Reference No:	2025/62/92281/E
Site Address:	7, Crown Flatt Way, Dewsbury, WF12 7TE
Description:	Erection of single storey rear extension with part two storey and part single storey side extension
Recommending Officer:	Elenya Jackson

DECISION – Conditional Full Permission

OFFICER REPORT

PROPOSED GROUND FLOOR PLAN

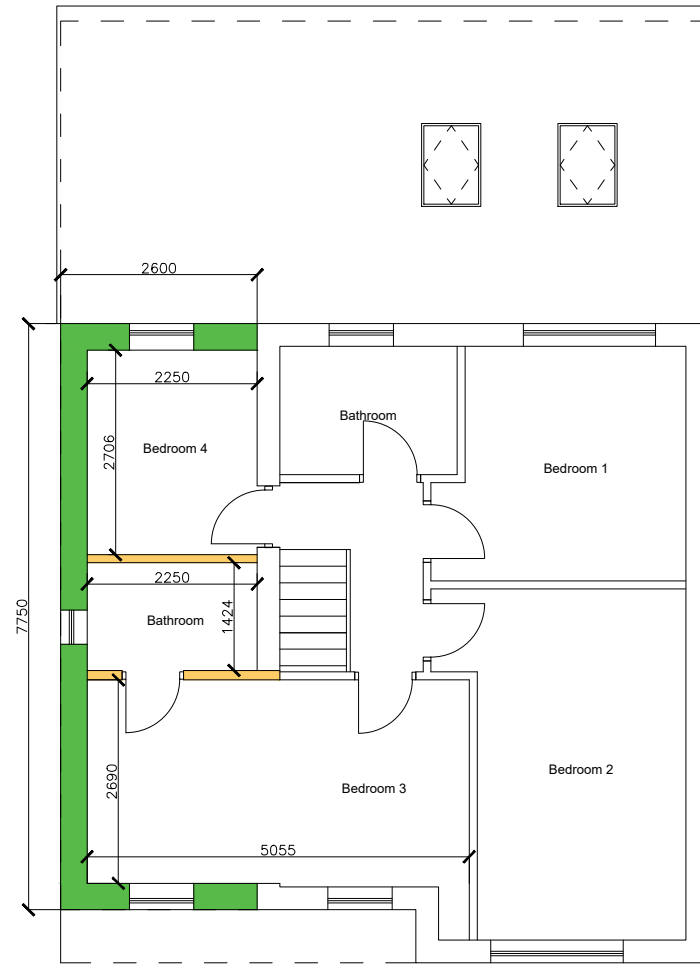
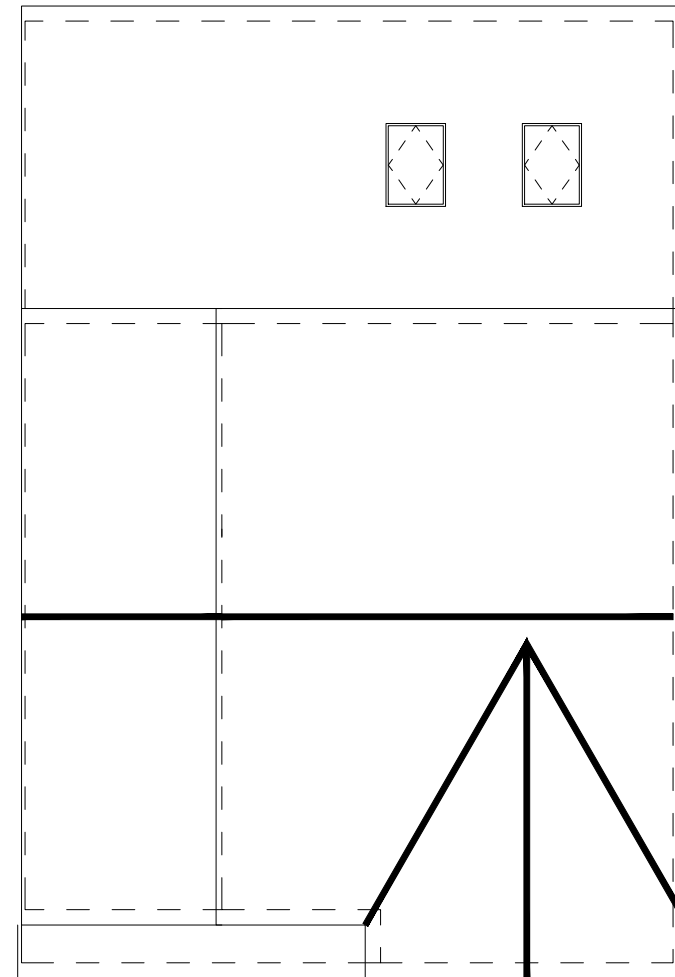
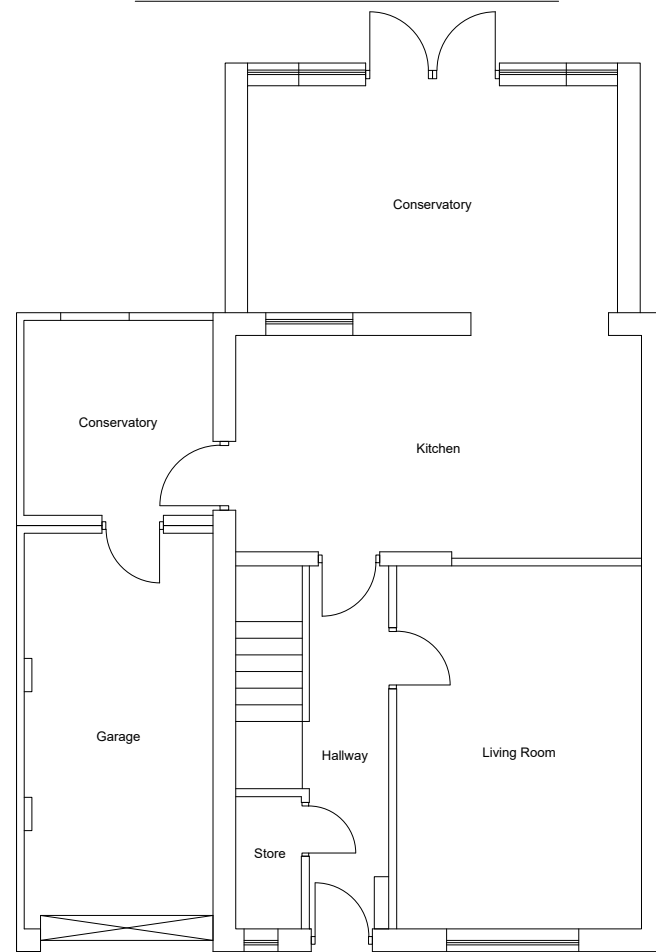
A two-storey side extension would infill behind the existing garage and include a first floor extension above the garage. The two storey side extension would extend 2.6m beyond the side elevation of the dwelling, have a depth of 7.7m and a maximum height of 7.3m.

A single storey rear extension would project 4m beyond the rear elevation of the dwelling and have a maximum height of 3.4m

The proposal would extend 4m beyond the rear elevation of the host property and have an eaves height of 2.5m. It is acknowledged that the proposal would not be set off the boundary by 1m; however, officers consider that the rear

extension would not be visible from the public realm. This element would replace an existing conservatory which has a similar projection. As such, the proposed extensions would comply with Policy LP24 of the KLP, KDP1 & KDP2 of the House Extensions and Alterations SPD and advice within chapter 12 of the NPPF.

The proposals would result in the loss of the existing integral garage, however the existing full width driveway to the front of the dwelling would be retained and this allows for provision for 3 vehicles to be parked off-street. As such the scheme would be acceptable in terms of highway safety and as such would comply with Policies LP21 and LP22 of the Kirklees Local Plan along with Key Design Principles 15 & 16 of the House Extensions & Alterations SPD.

PROPOSED SIDE ELEVATION
(South East)

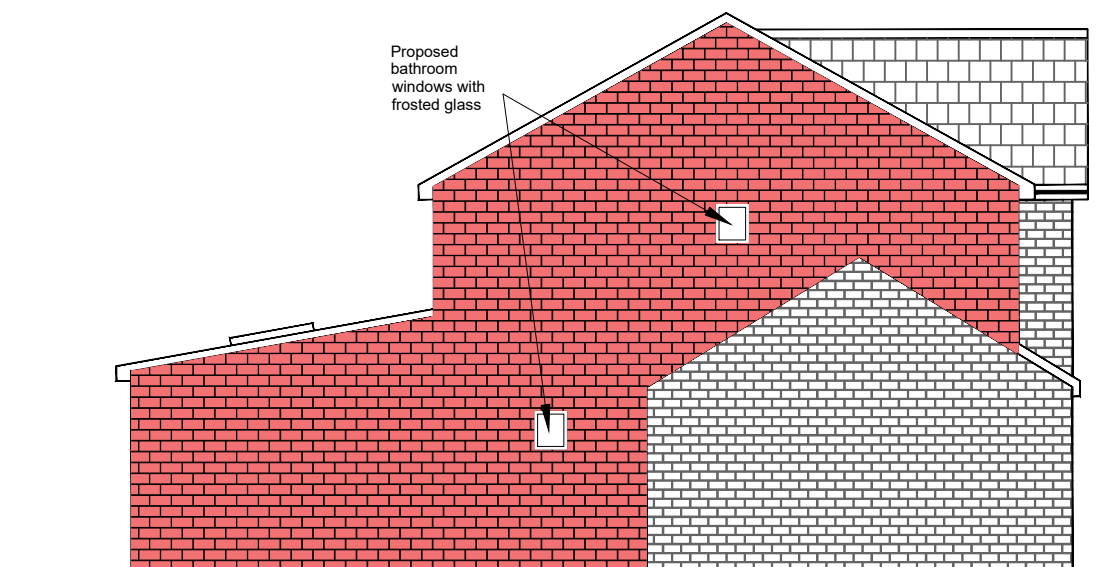
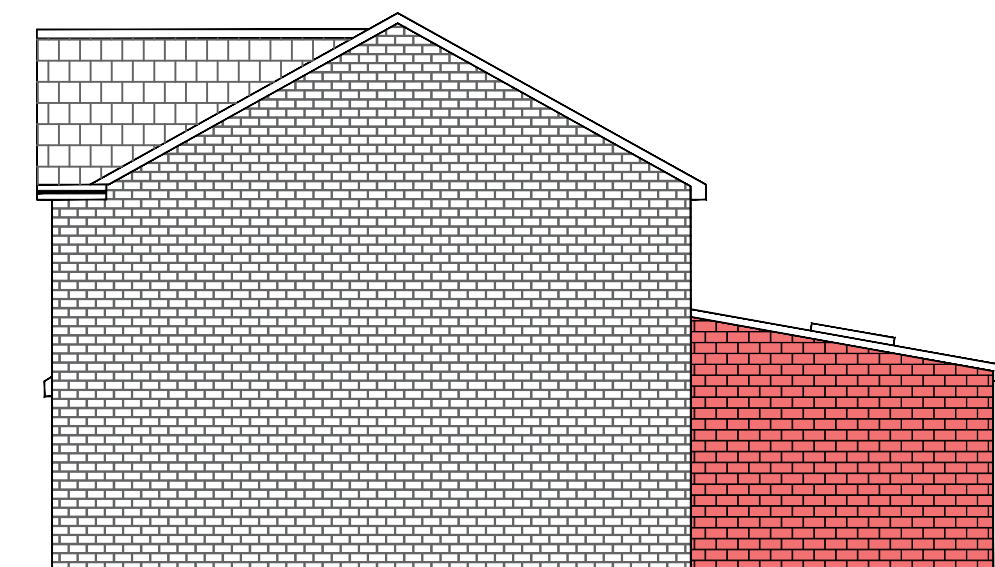
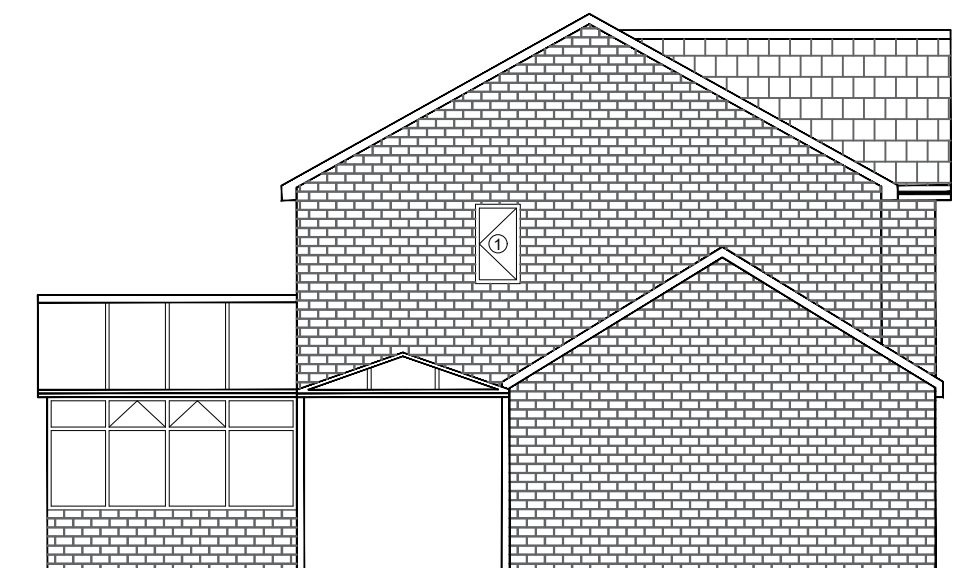
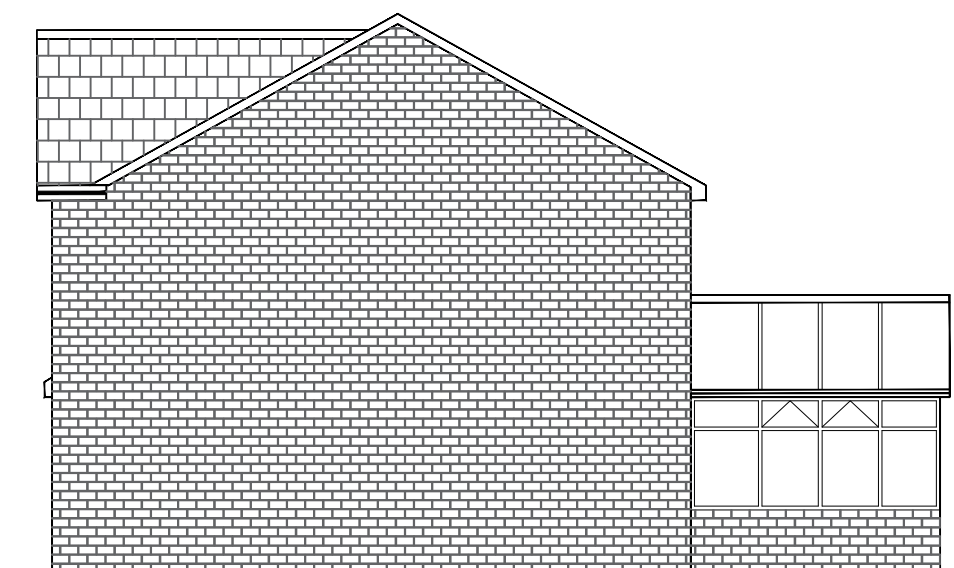
Overlooking: The proposal would not feature any side facing windows and as such, would not result in a loss of privacy to the occupants of No.5.

Overlooking: The proposal would not feature any side facing windows and as such would not result in a loss of privacy to the occupants of No.9

Overshadowing/loss of light/overbearing: The proposed two storey extension would be screened by the host dwelling. The proposed single storey extension would have an eaves height of 2.5m and would not sit within the vertical visibility splay of any habitable room windows at no.9.
